# CITY OF PORTLAND BUILDING PERMIT

**PERMIT ID:** 2013-00256

68 COMMERCIAL ST - MAINE WHARF - end  
of Building A)

has permission to **Repair part of existing Building 'A' (interior work) - 40' x 39' area - use is undetermined at this point - need to apply for tenant fit up permit when occupied** provided that the person or persons, firm or corporation accepting this permit shall comply with all of the provisions of the Statues of Maine and of the Ordinances of the City of Portland regulating the construction, maintenance and use of the buildings and structures, and of the application on file in the department.

TABLE 1015.1
B: MAXIMUM ALLOWABLE OCCUPAN LOAD WITH SINGLE MEANS OF EGRESS = 49 OCCUPANTS
SINGLE MEANS OF EGRESS PROVIDED
B: 1,500 SF/100 = 15 OCCUPANTS
THEREFORE, SINGLE MEANS OF EGRESS PROVIDED.

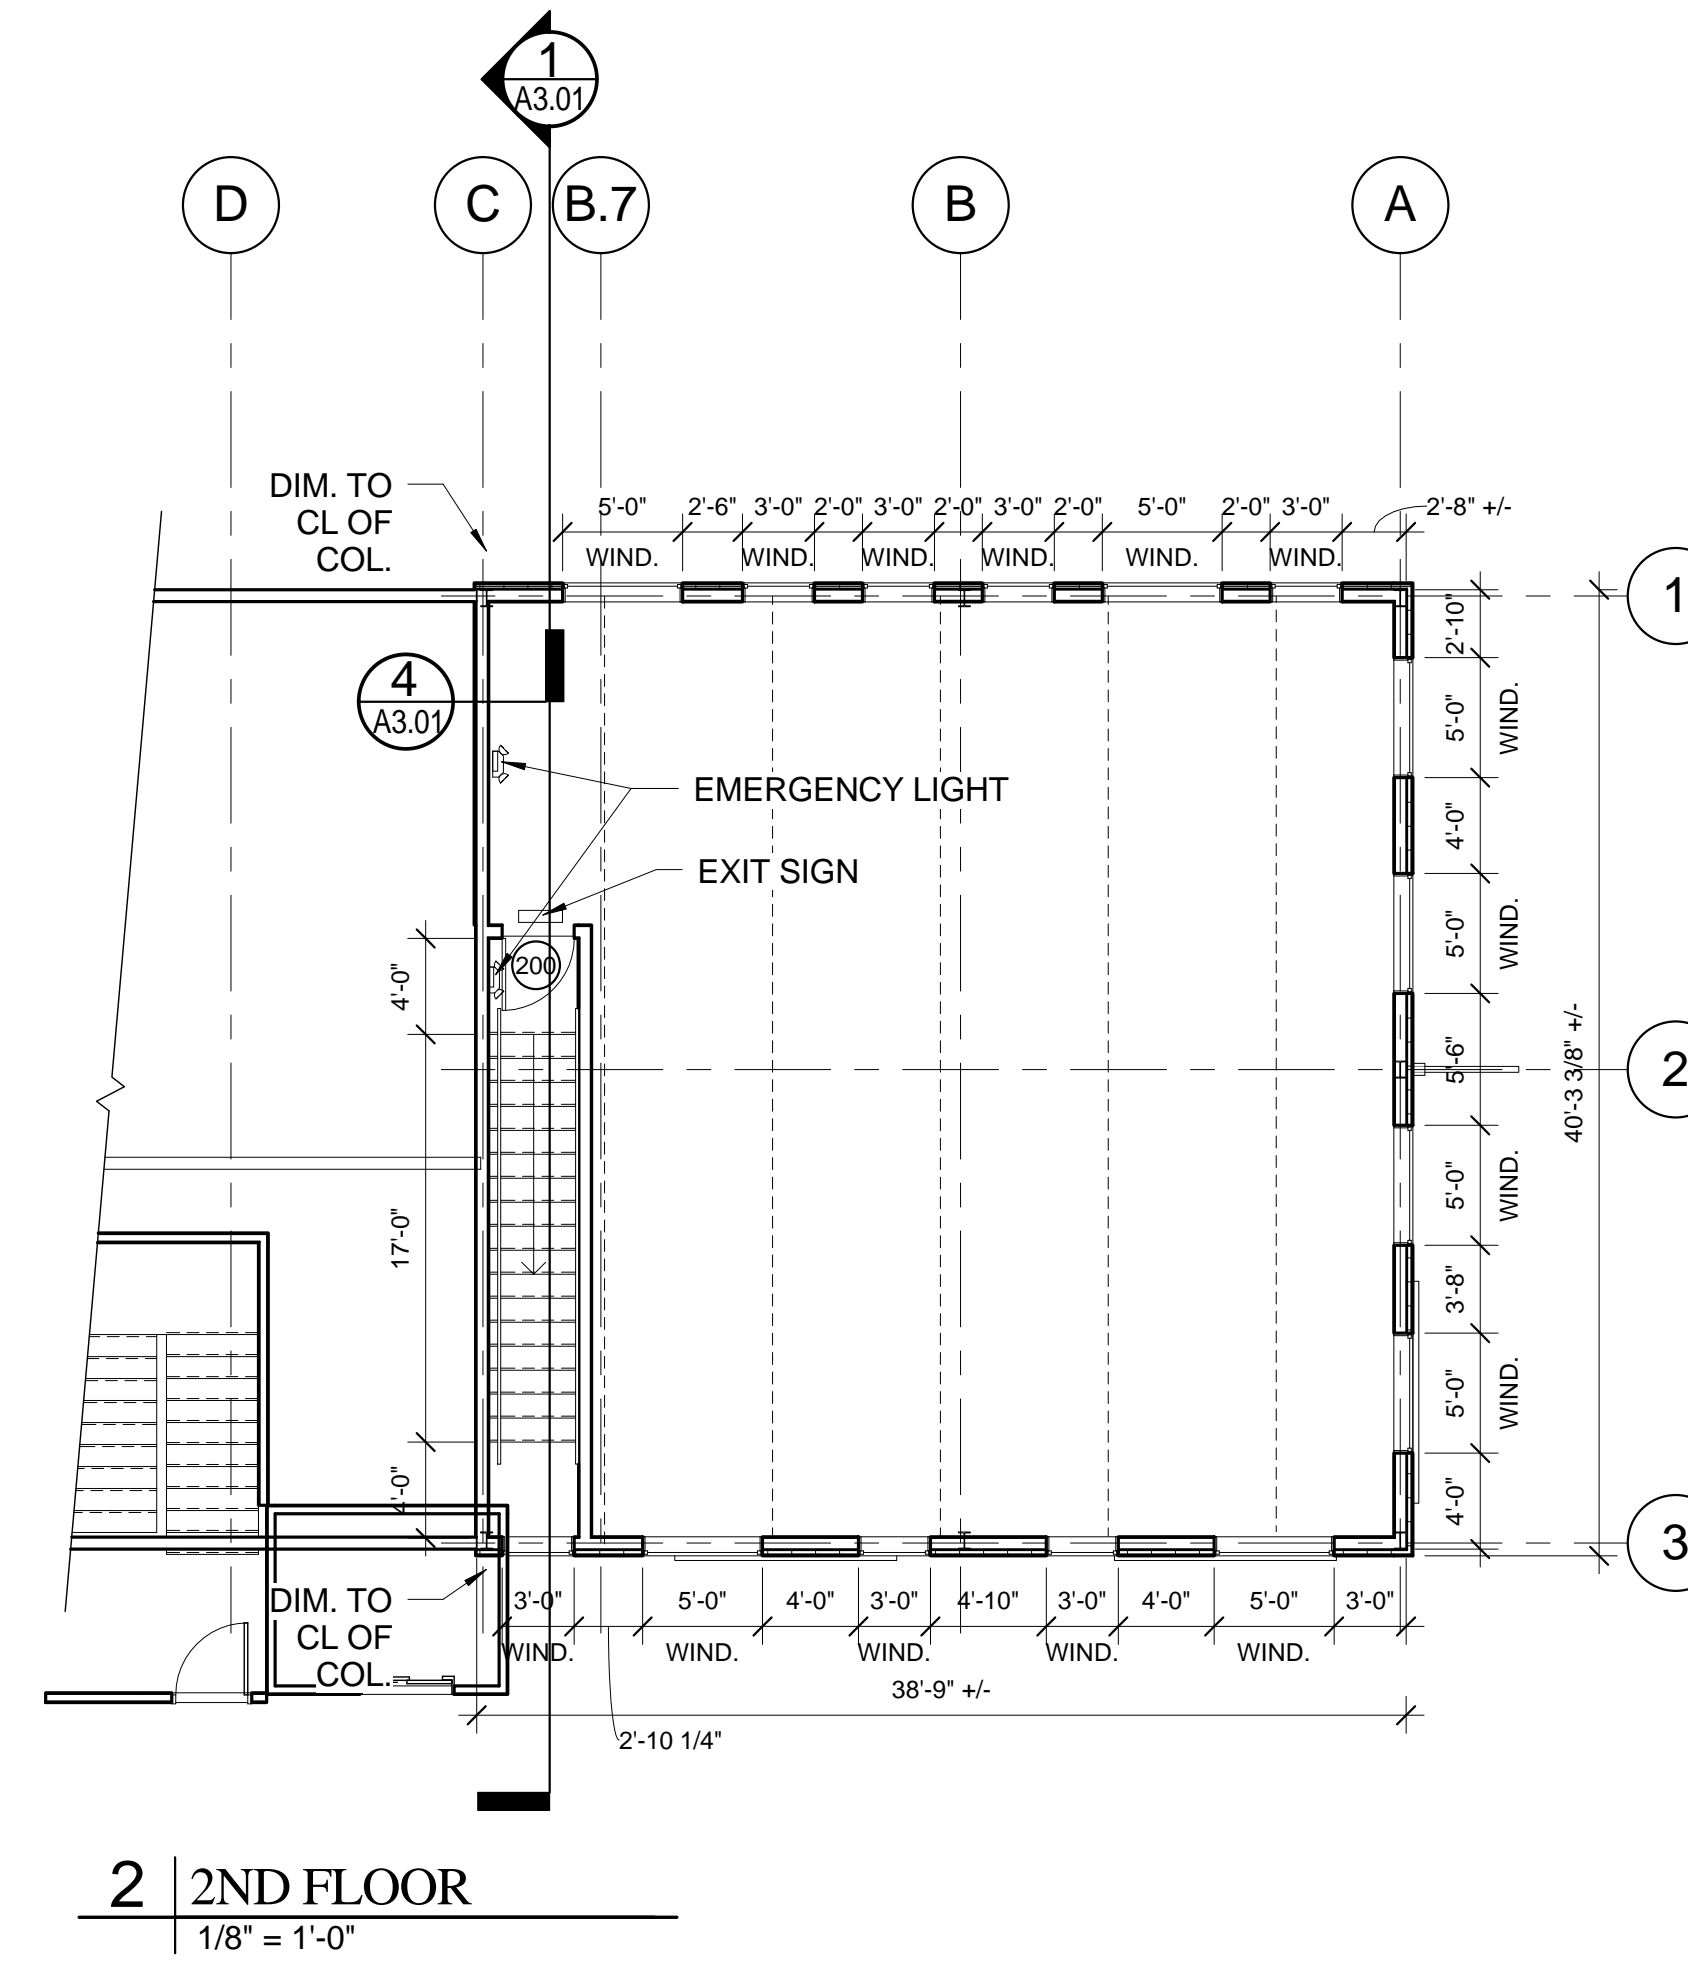
Requiring Code Analysis from the design professional in responsible charge, and clarification on of elevations, separations, and uses.
